**From:** Charlotte Thomas <charlotte.thomas@bartonwillmore.co.uk>  
**Sent:** 08 June 2022 12:48  
**To:** Richard Phillips  
**Cc:** Ed Pigott; Scarlett Lambeth  
**Subject:** RE: Silverdale House, Pump Lane, Hayes (Application Ref: 49670/APP/2022/974)

On the submitted proposed elevations, the proposed cladding material is 'Tata steel Trisomet panel RAL 7000 (grey)' whereas the submitted manufacturer's information is for 'Euroclad Elite System 51.35 wall cladding'. Can you please clarify if they are the same or different products (I note they are 'both' made by Tata Steel). If the latter is different, you will need to specify the RAL colour.

Project
Silverdale House
Hillingdon
Drawing Title
Proposed Elevations

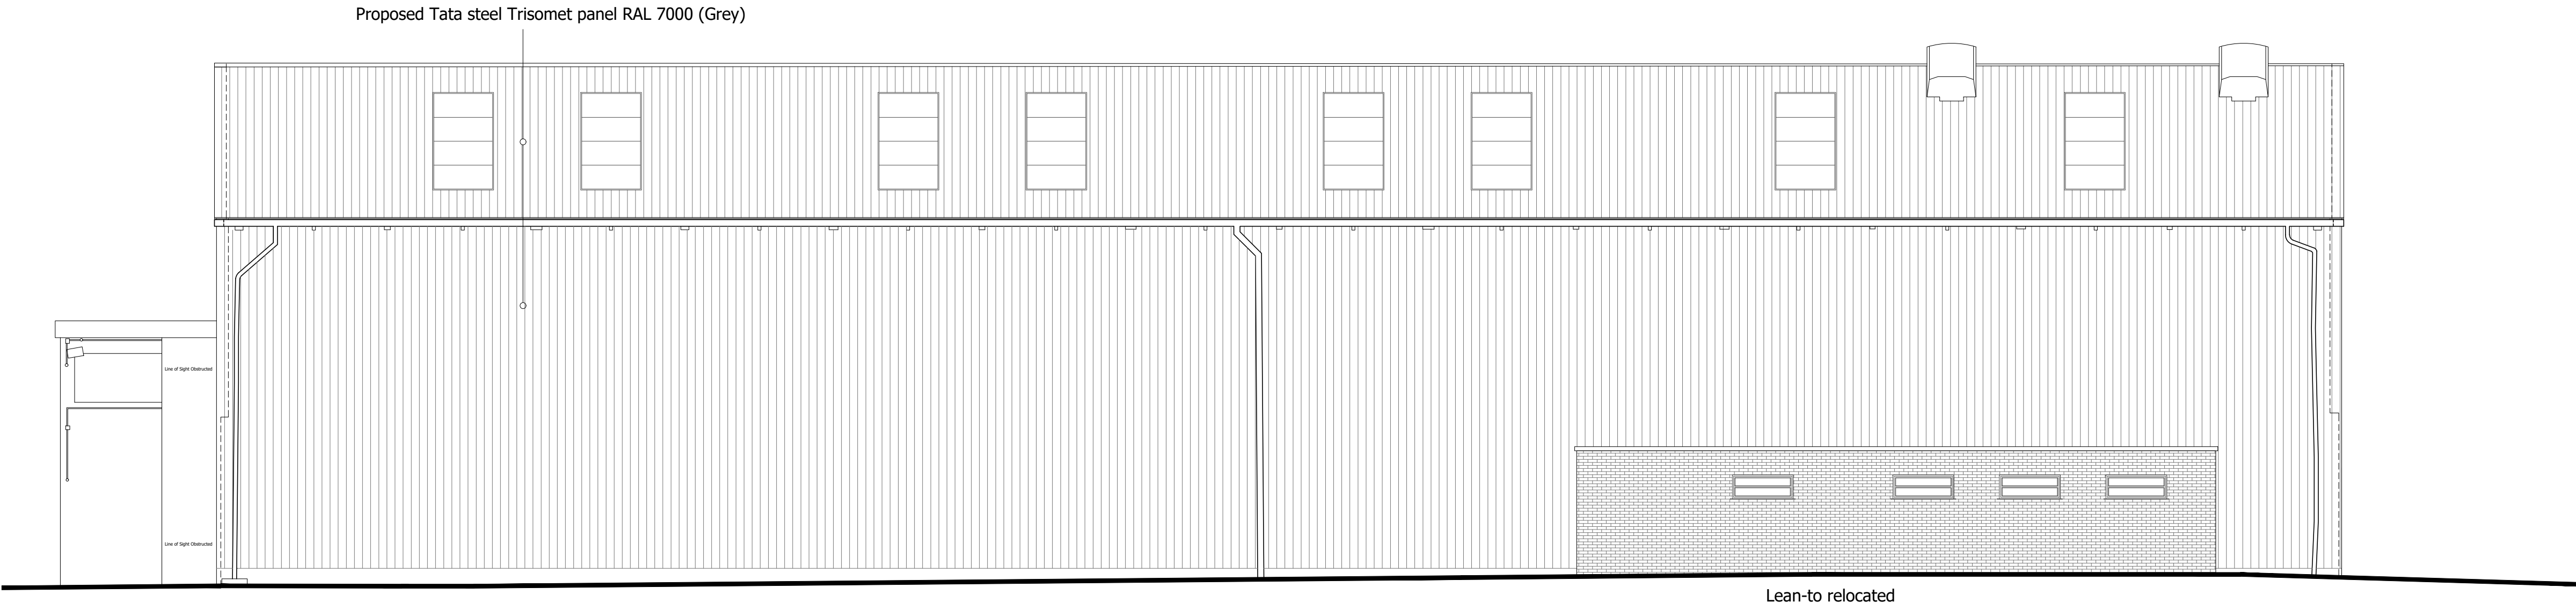
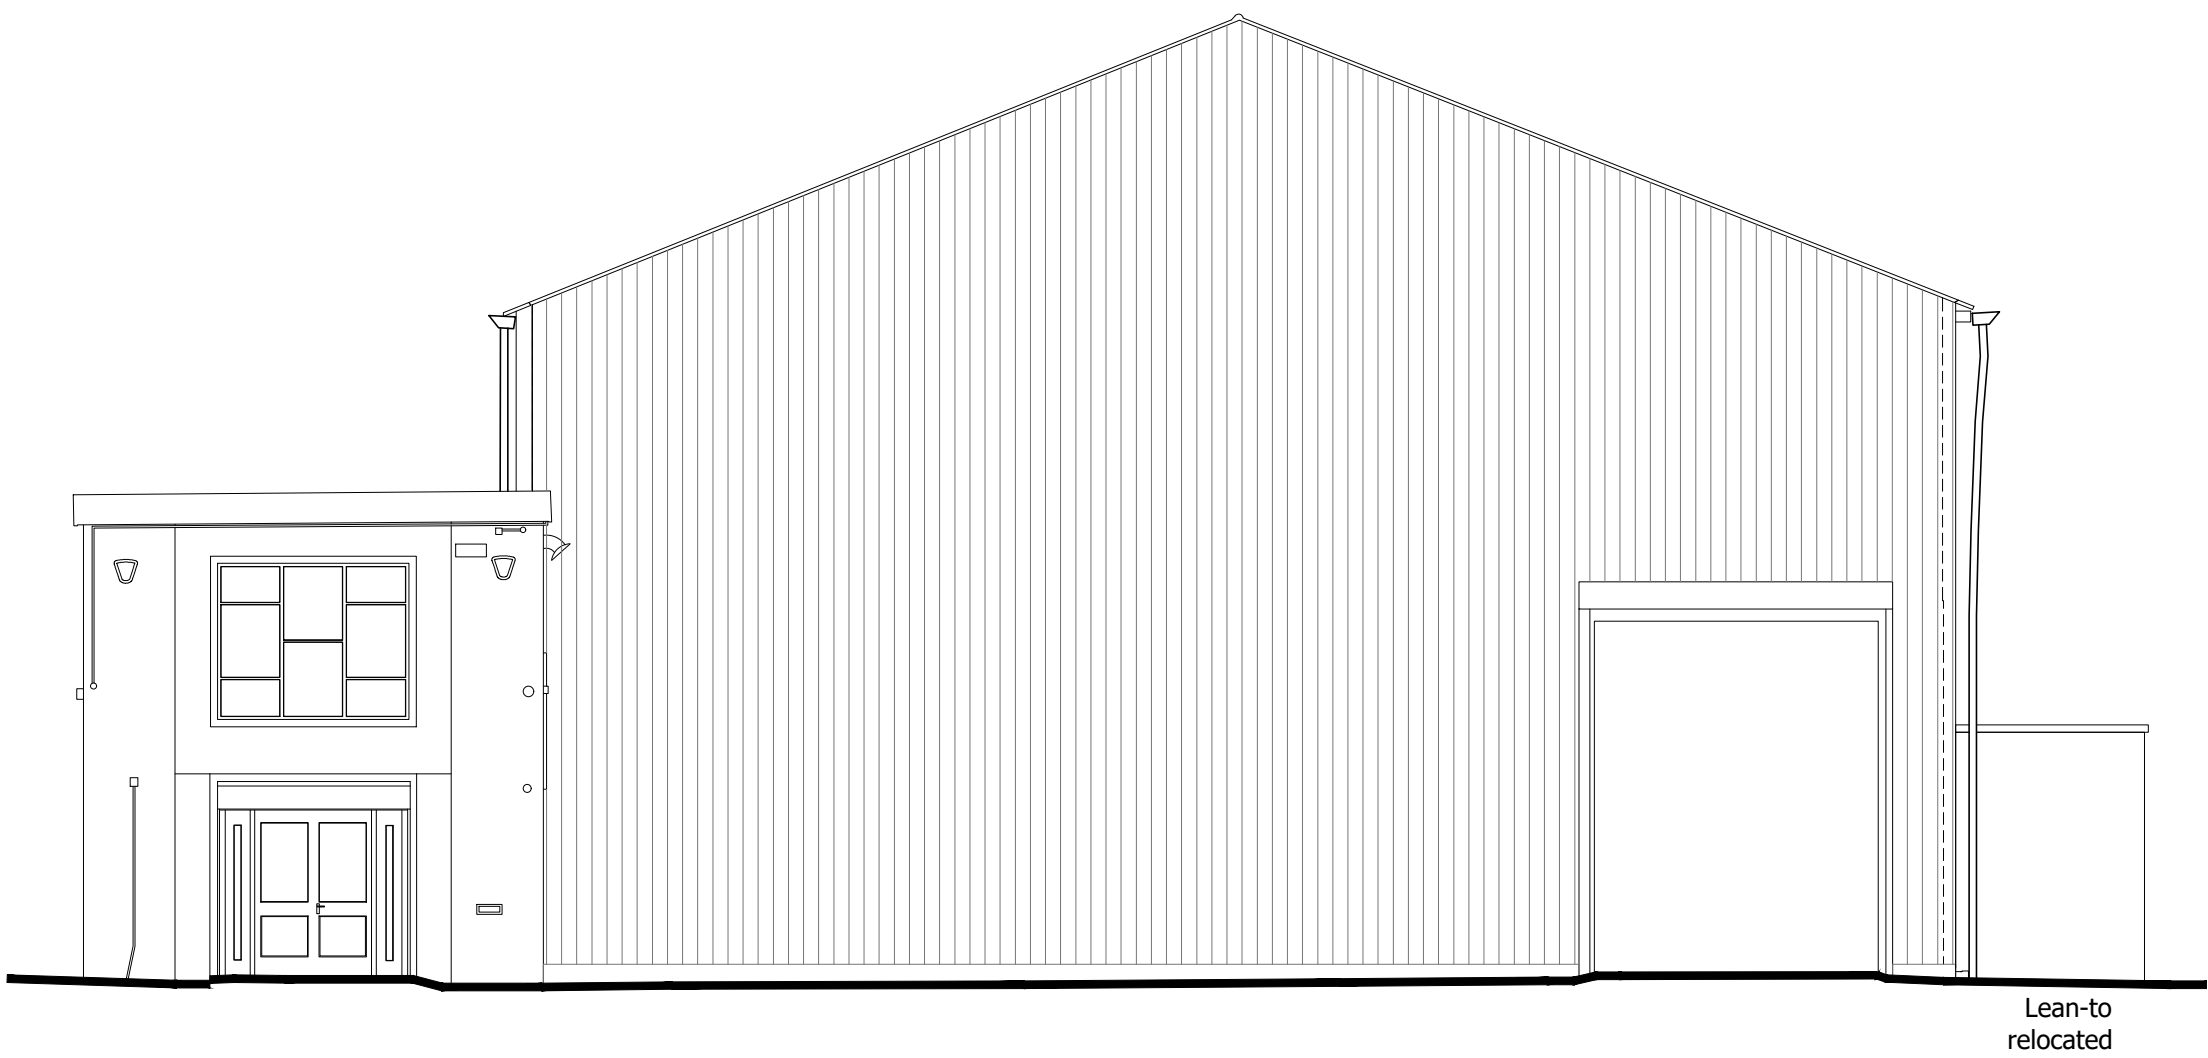
On the submitted proposed elevations, the proposed cladding material is 'Tata steel Trisomet panel RAL 7000 (grey)' whereas the submitted manufacturer's information is for 'Euroclad Elite System 51.35 wall cladding'. Can you please clarify if they are the same or different products (I note they are 'both' made by Tata Steel). If the latter is different, you will need to specify the RAL colour.

I also note that no information has been provided for the material / cladding to be used on the roof. Will this be the same? Also, the proposed roof plan / side elevations show a total of 16 panels in the roof (8 on each side) but no information has been provided as to what these are. I assume they are skylights / glazed panels but can you please confirm.

**The spec to be used is EUROCLAD CLADDING SHEET (HPS200 Alaska Grey RAL7000).**

**The cladding on the roof will be EUROCLAD TOP SHEET (HPS200 Alaska Grey RAL7000) and the 16 panels are to be rooflights.**
